SECTION 73 APPLICATION FOR THE VARIATION OR REMOVAL OF CONDITIONS ATTACHED TO PLANNING APPLICATION DC/21/06729.

LAND WEST OF ROSEMARY, CHURCH ROAD, STOWUPLAND, SUFFOLK IP14 4BG

CONDITIONS TO BE VARIED; 2, 10, 11, 14
CONDITIONS TO BE REMOVED; 4, 5, 6

Drawing No. 22023-13

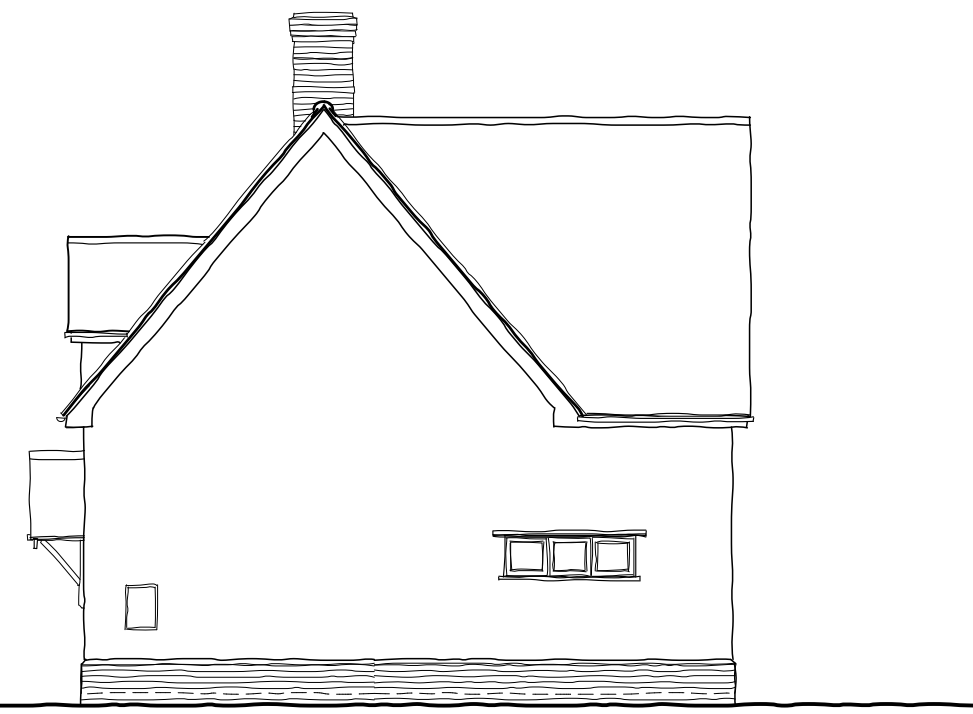
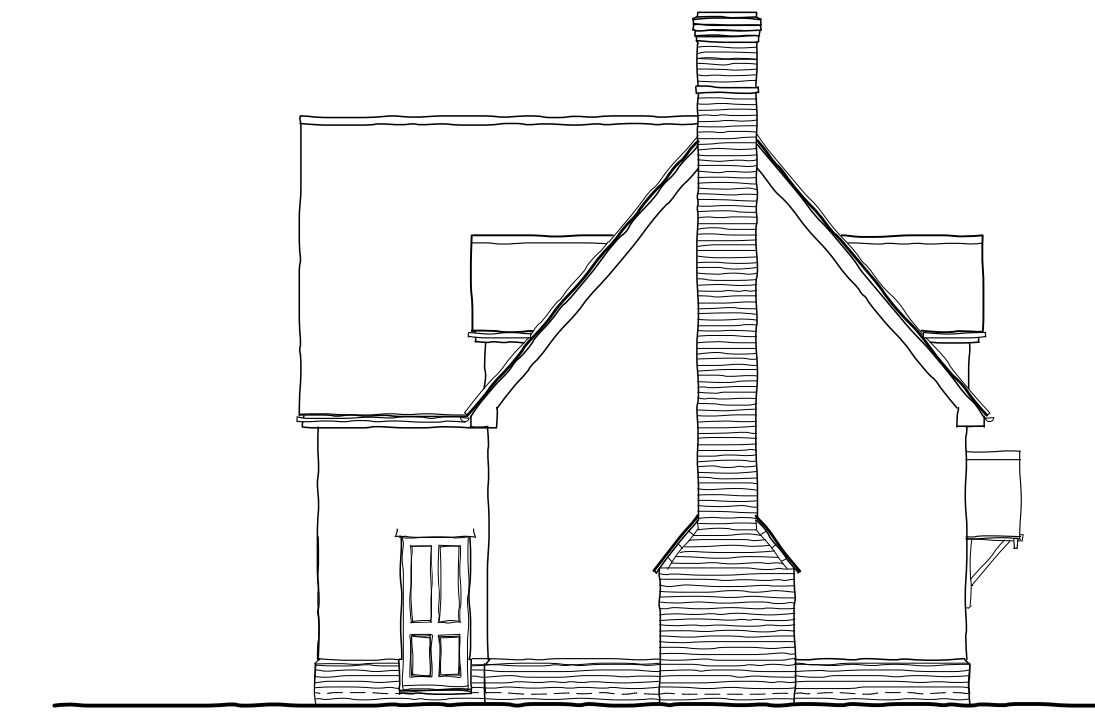
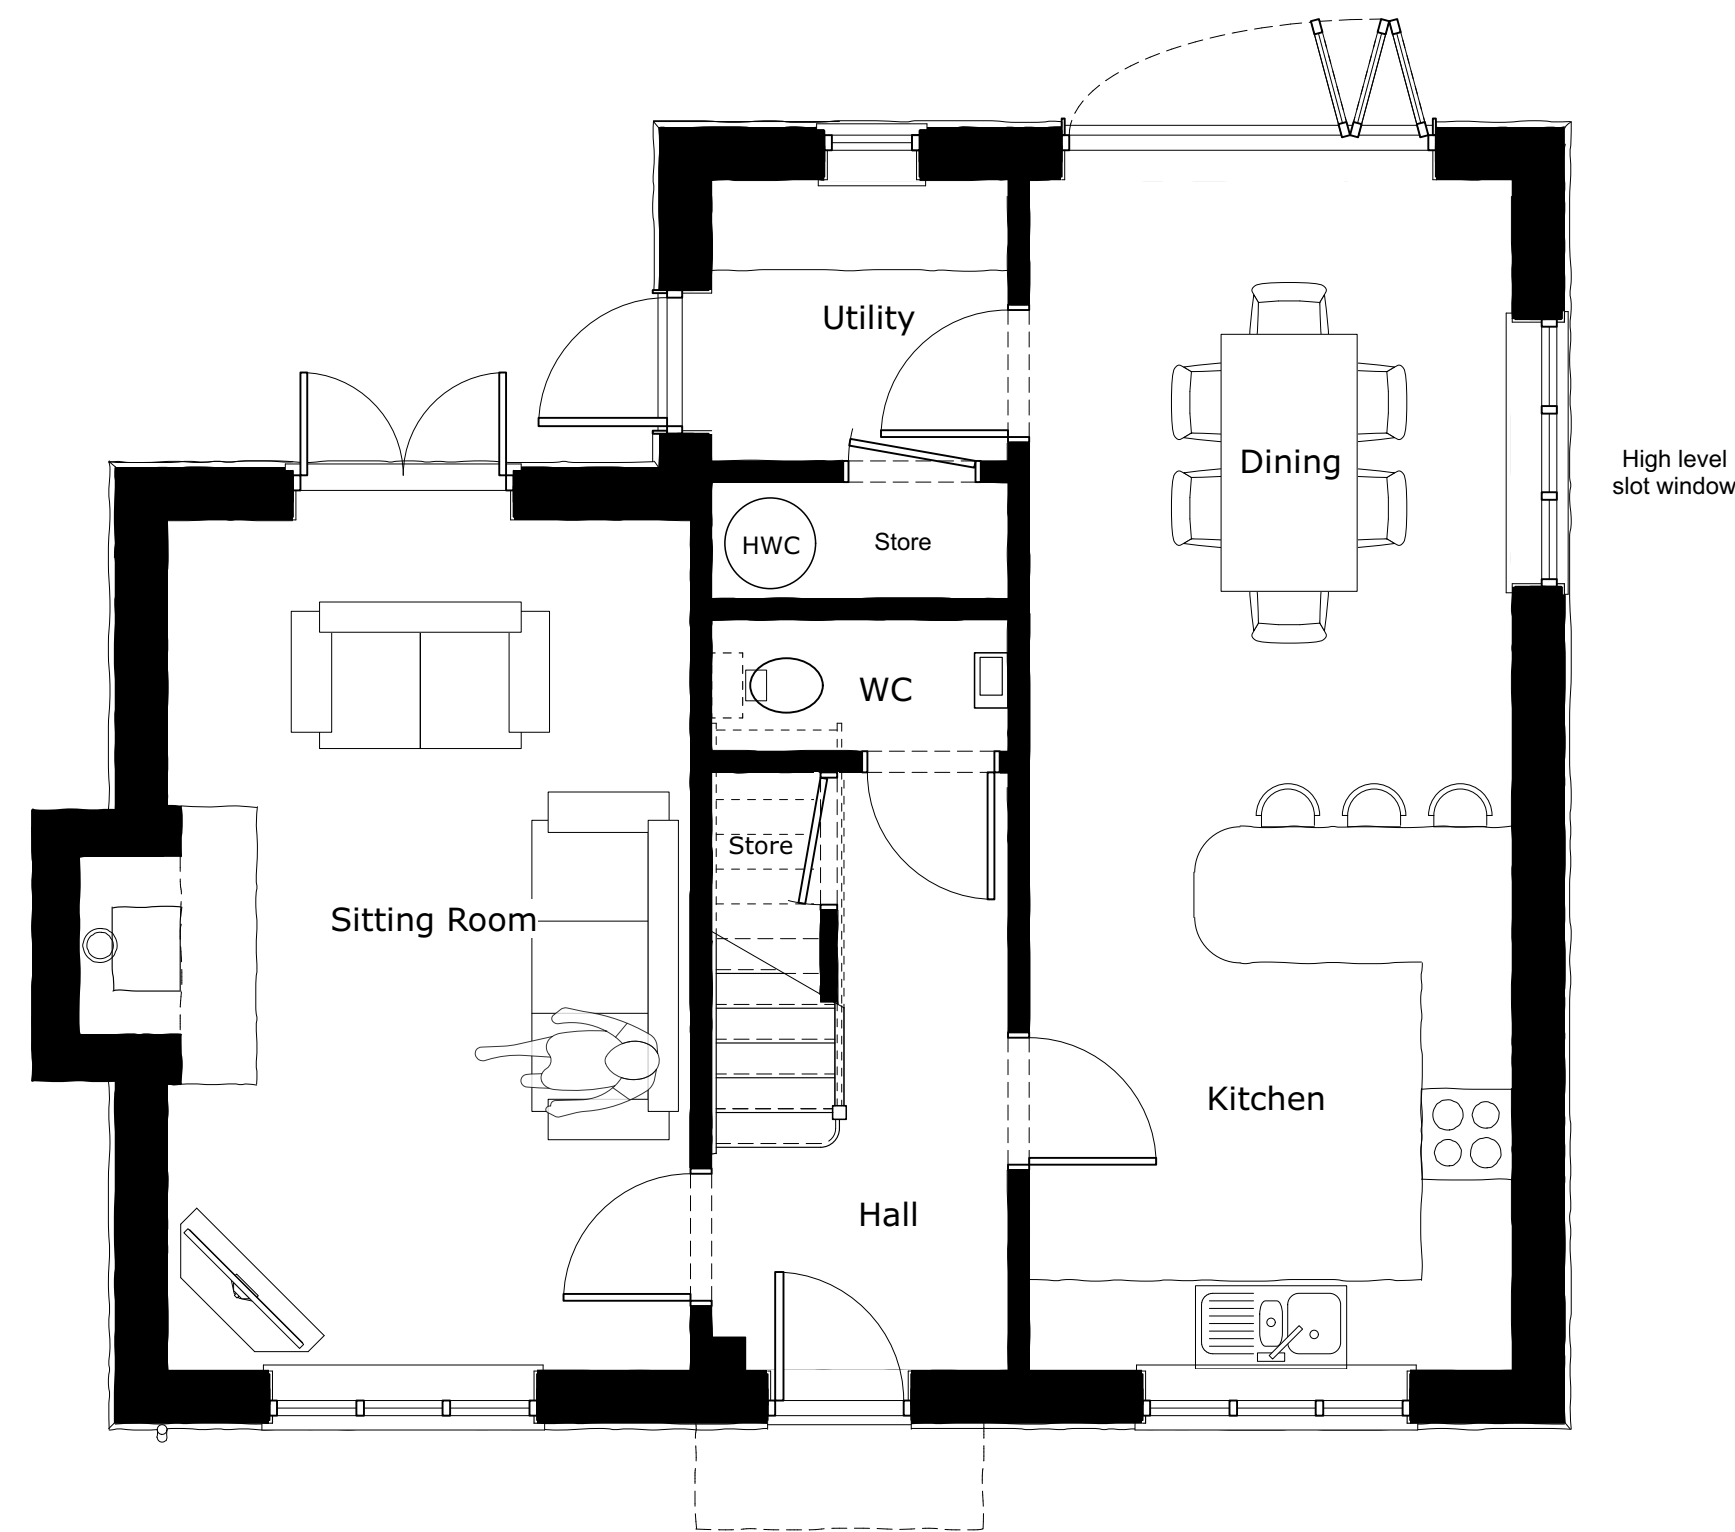
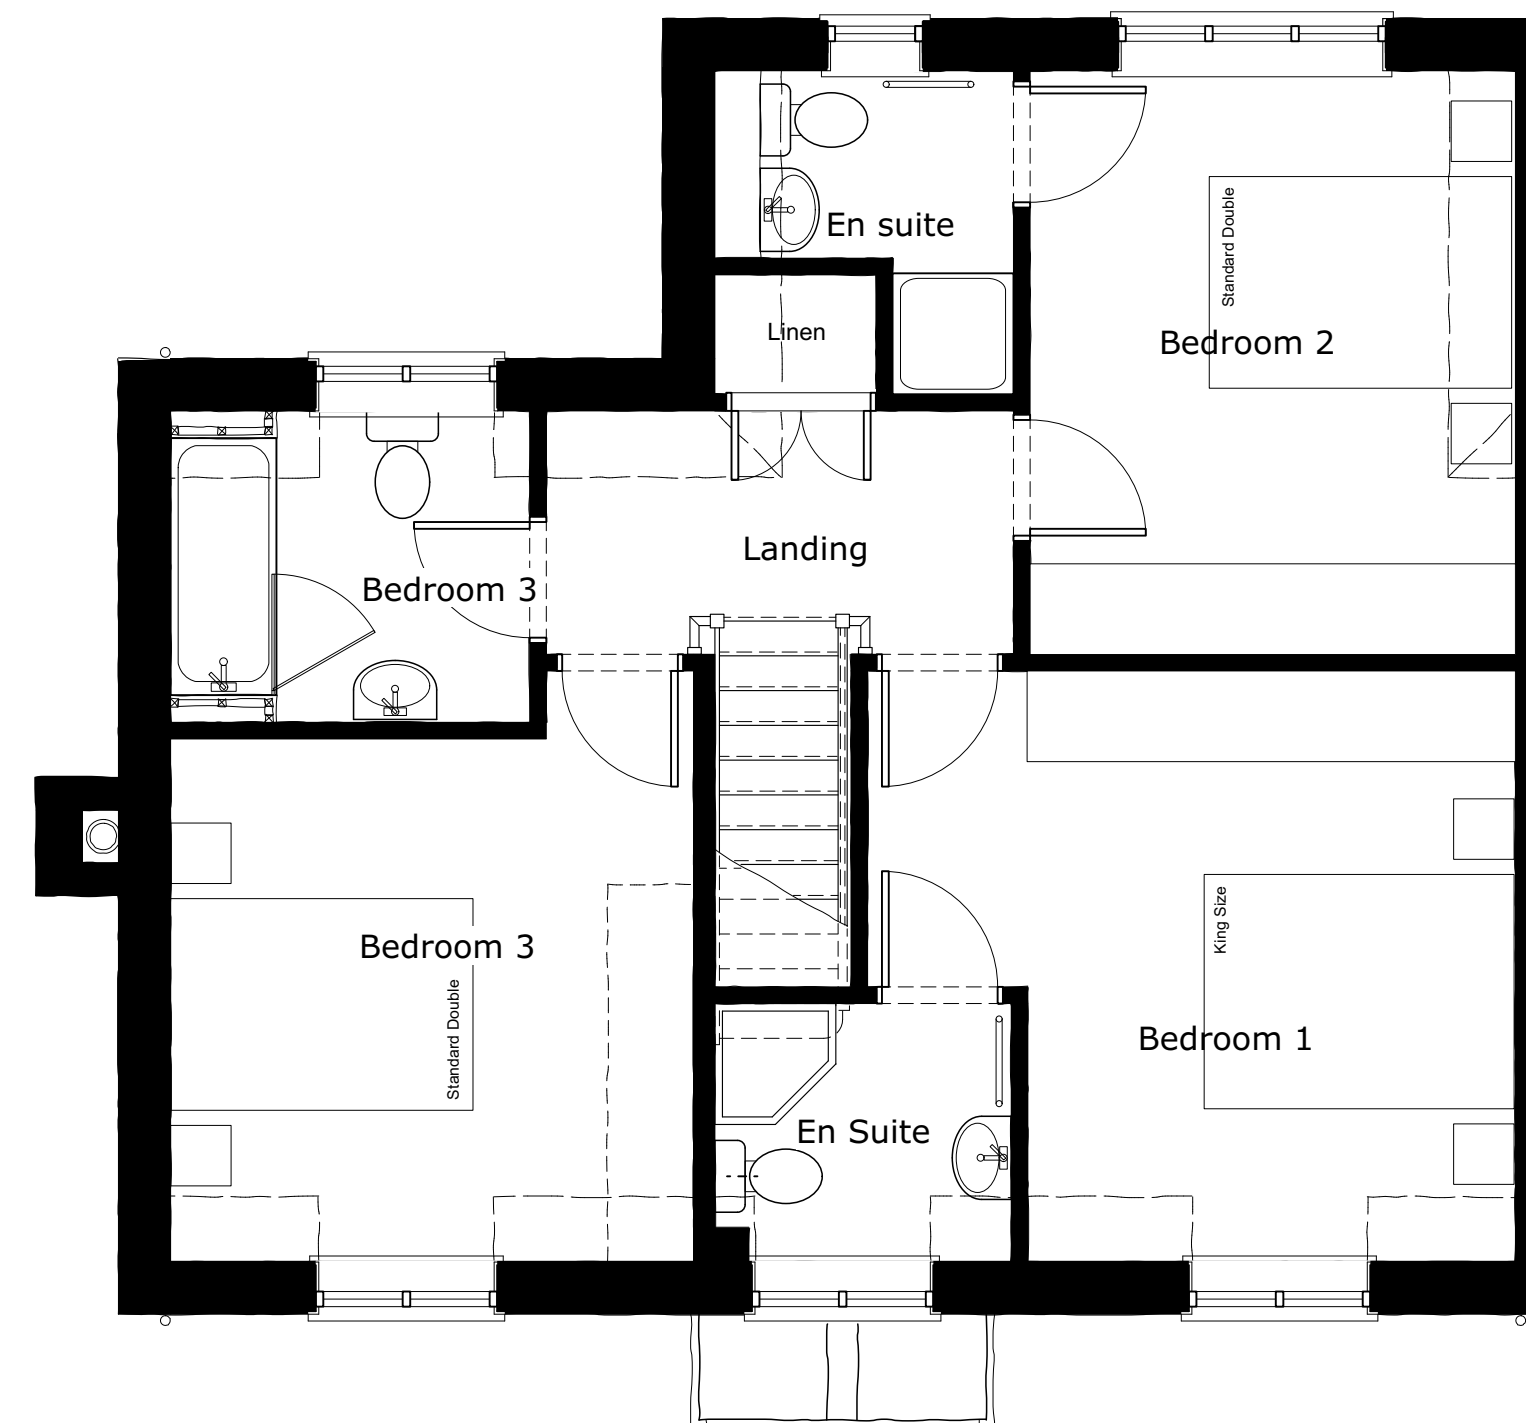
Plot 1 Floor Plans and Elevations

- Change to rear elevation and rear roof to create a rear gable.
- The rear wall is extended 1 metre to the north.
- Rearrangement of internal room layout.

The main change to Plot 1 is the introduction of a gable to the rear elevation.. This design change makes this plot more attractive and breaks up what would have been a long expanse of roof. The previously approved design included an existing window at the same height and facing the same direction as the newly introduced rear window so there is no additional overlooking of the neighbouring garden created by this change.
